FIRE RISK MANAGEMENT, INC

Memo Report

From: W. Mark Cummings, P.E.
To: Mr. Eric Michaud; Infiniti
CC: Capt. Chris Pirone; Fire Prevention Division, Portland Fire Department
Subject: **Fire Hazards Assessment of the In'finiti Fermentation & Distillation Site at 250 Commercial St., Portland, ME.**

A review has been conducted of the proposed layout/construction for a new brew pub, with a small distilling operation, which is to be located within a newly renovated space on the 1st floor of a commercial building at 250 Commercial Street in Portland, ME. The purpose of this review was to evaluate the proposed inclusion of a small distillery operation within the brew pub, including the potential fire/explosion hazards that may exist and assess the need to provide adequate fire separation of this operation from the remainder of the brew pub. The end result for this assessment is to develop recommendations to ensure that adequate fire and life safety are provided within the facility.

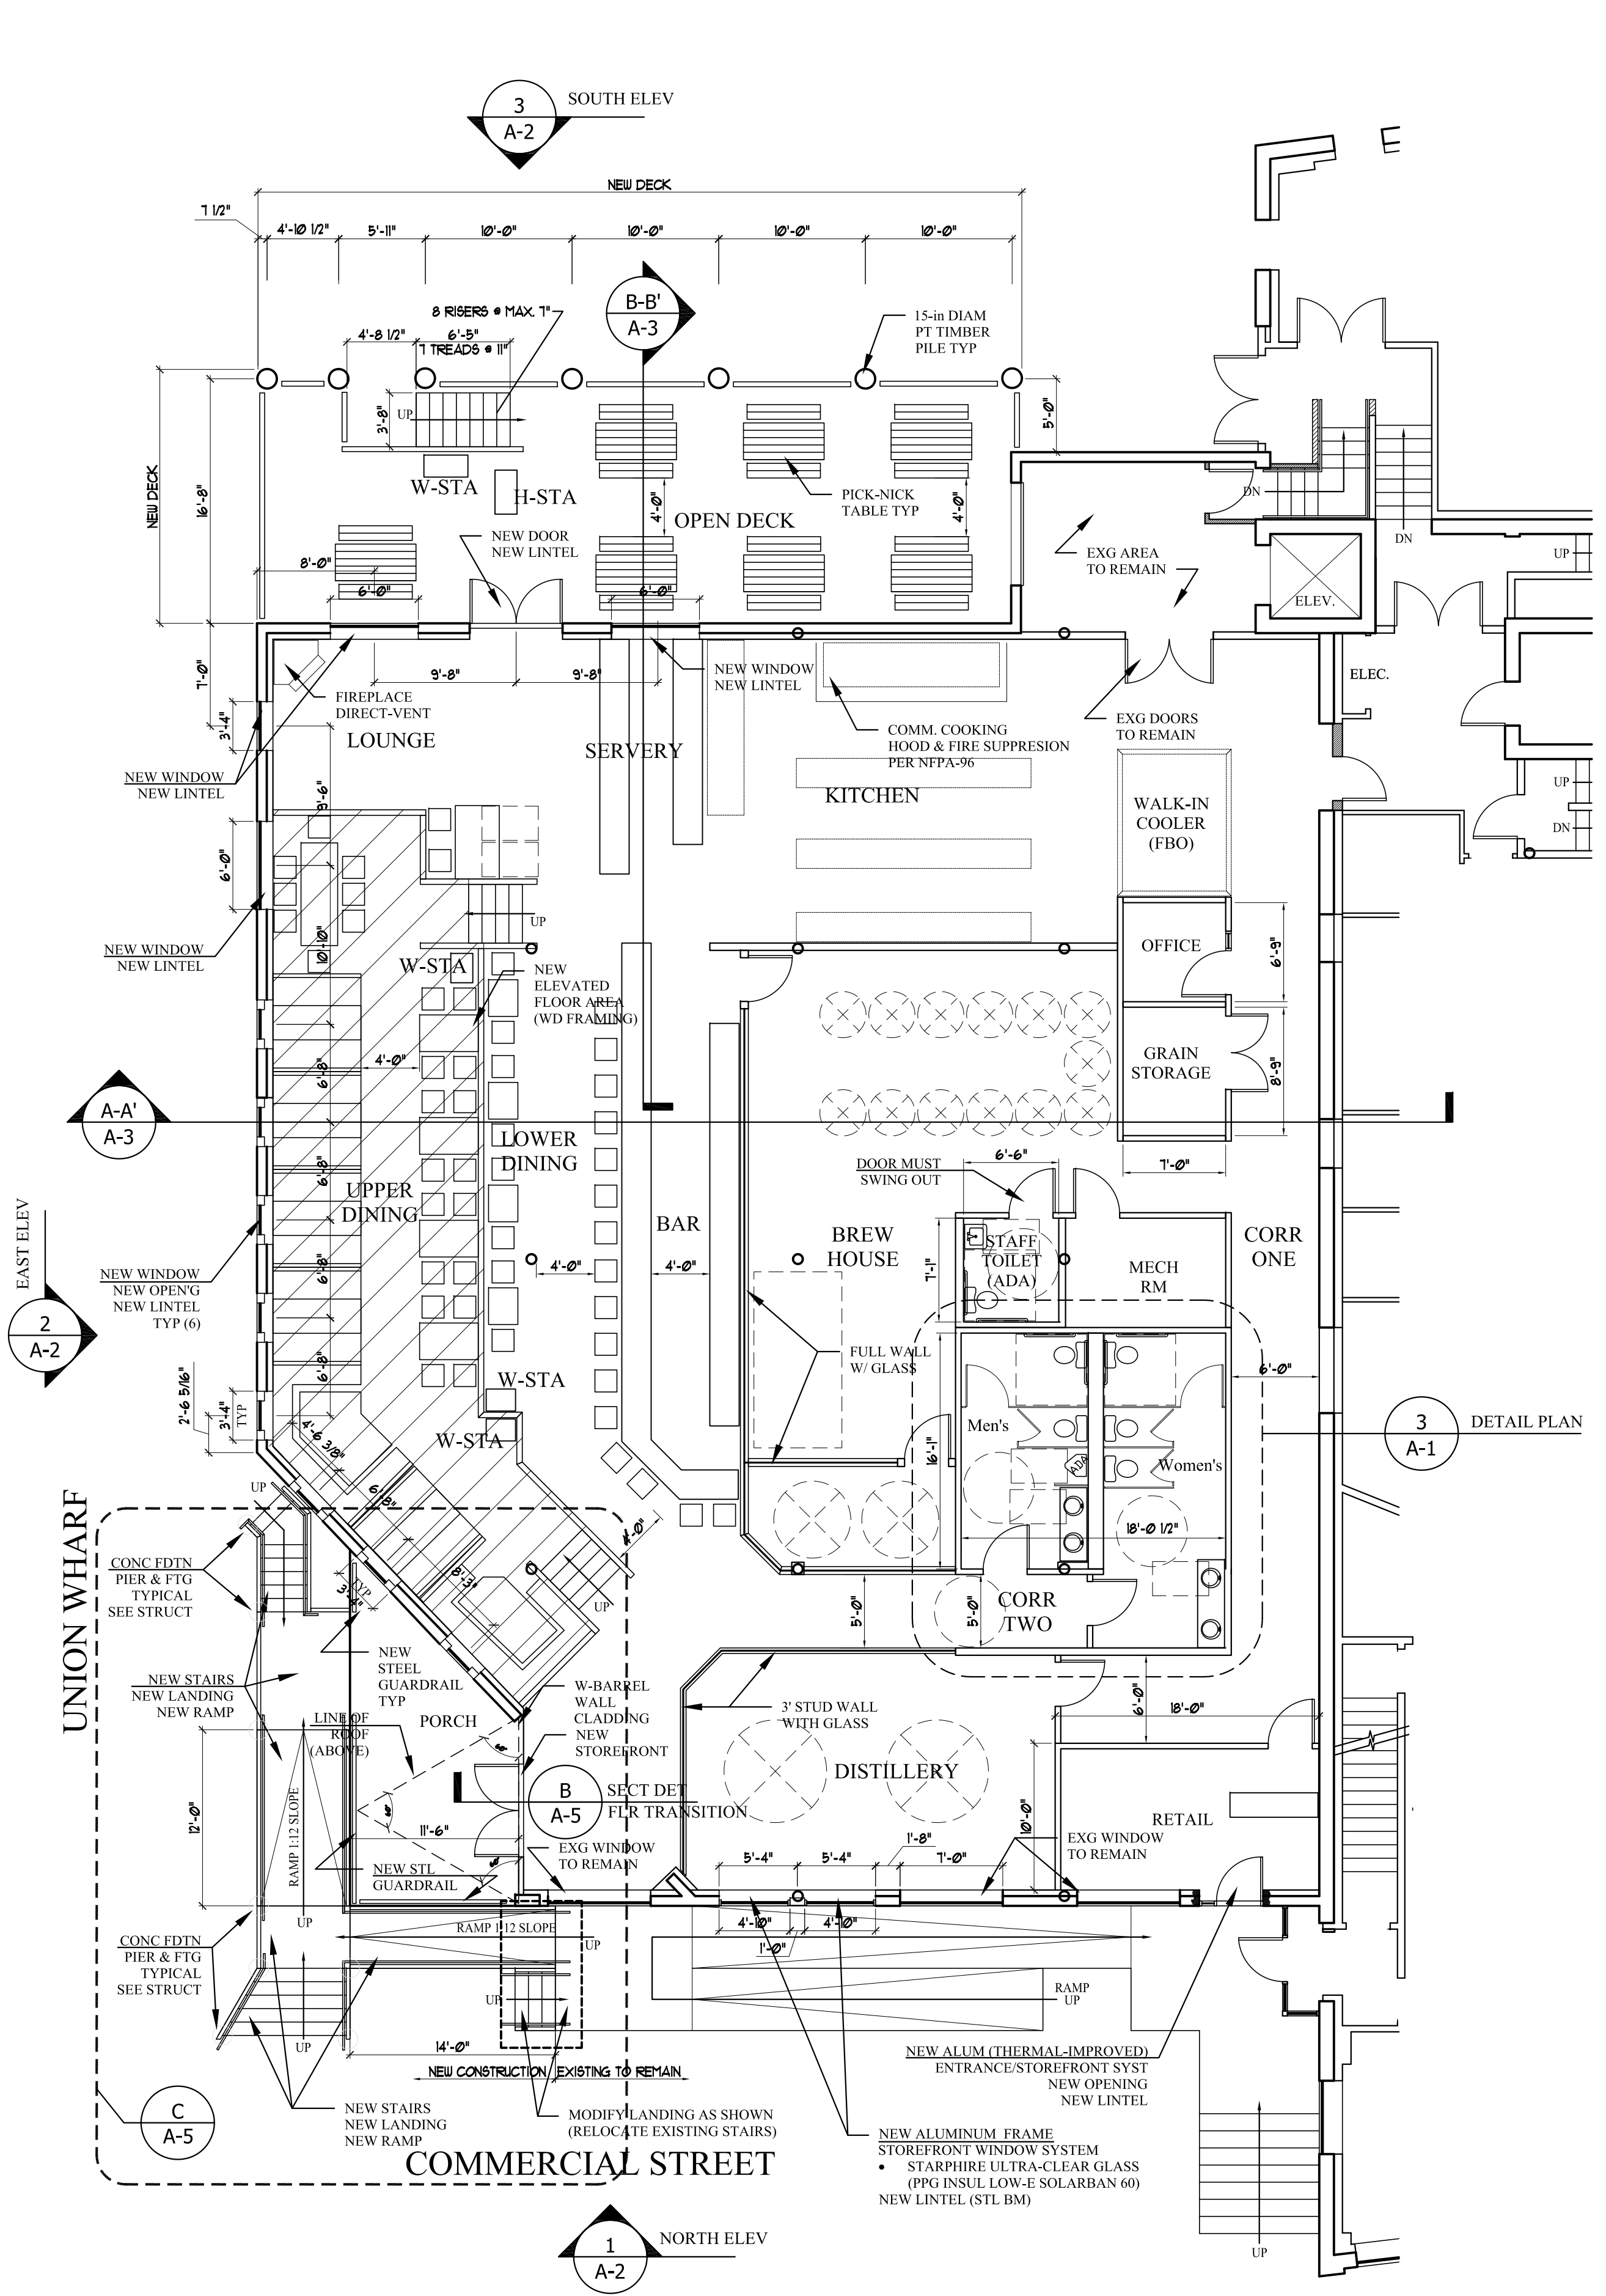
The actual code requirement for including a fire separation between the distilling area and the remainder of the brew pub area is a bit vague; in light of this specific application. However, it was stated by the owner that they had agreed to provide a 1-hour separation; which coincides with the IBC requirements for separation of an Assembly occupancy from a (low hazard) Factory/Industrial occupancy. However, it is also desired by the owners that the distilling operations be “viewable” by their patrons and the design of the separation wall(s) include the installation of glass viewing windows on two of the interior walls. Given the expense associated with fire-rated glass, coupled with the relatively low hazard nature of the distilled spirits, the use of an alternative approach to providing the adequate separation may be worth consideration. NFPA 101 allows for the use of sprinklers to protect glass installed in the walls of an atrium, where it is often desirable that the building design include the ability to view the atrium from adjacent spaces. Although this application is considerably different from that of an atrium, the basic premise is the same. This, coupled with the low fire hazards associated with the distilling operation and the fact that the spirits are miscible with water and would quickly be diluted below the point at which they would sustain combustion, use of this approach is considered to be an acceptable and safe alternative. If employed, the requirements of Section 8.6.7 (1)(c) of NFPA 101 must be followed; with respect to the window design/installation, along with the spacing of the sprinklers near the windows. Given that, unlike an atrium, a fire hazard exists on both sides of the barrier, it would be

recommended that the sprinklers installed to protect the glass be installed on both sides of the barrier. This configuration should be adequate to provide the necessary protection of the glass to maintain the 1-hour fire separation.

3. Consider a modification to the current supply ventilation ducting in the distilling area that would allow supply air to be provided at a level within 12 inches of the floor. An exhaust system needs to be added to this area; with the inlet within 12 inches of the floor and at a location that is opposite from the supply. An air flow rate (inlet and exhaust) of at least 400 cfm should be provided, but as a minimum, the exhaust rate must be equal to or greater than the supply rate to ensure that the area is not under “positive” pressure. This to prevent any vapors from exiting the distilling area.

1. Incorporate the use of a containment “berm” that surrounds the areas where the still and stainless steel tanks, are to be installed, along with providing additional area within the containment berm to allow filling operations within this containment area.

2. Ensure that any electrical systems/equipment that is to be installed within the distilling area and that is within three (3) feet of the floor meet the requirements for a Class I, Division 2 (Zone 2) installation, as outlined by NFPA 70.

4. If the sprinkler-protected glass option is to be used as part of the fire separation scheme to isolate the distilling area, ensure that all requirements within Section 8.6.7(1)(c) are adhered to.

5. To ensure that adequate fire protection is provided in light of the maximum quantities of flammable liquids (distilled spirits) that may be stored within the distilling area, it is recommended that the sprinkler system be designed to provide a water density that is commensurate with protection of an Ordinary Hazard, Group 2 occupancy classification, as outlined in NFPA 13, *The Standard for the Installation of Sprinkler Systems*.
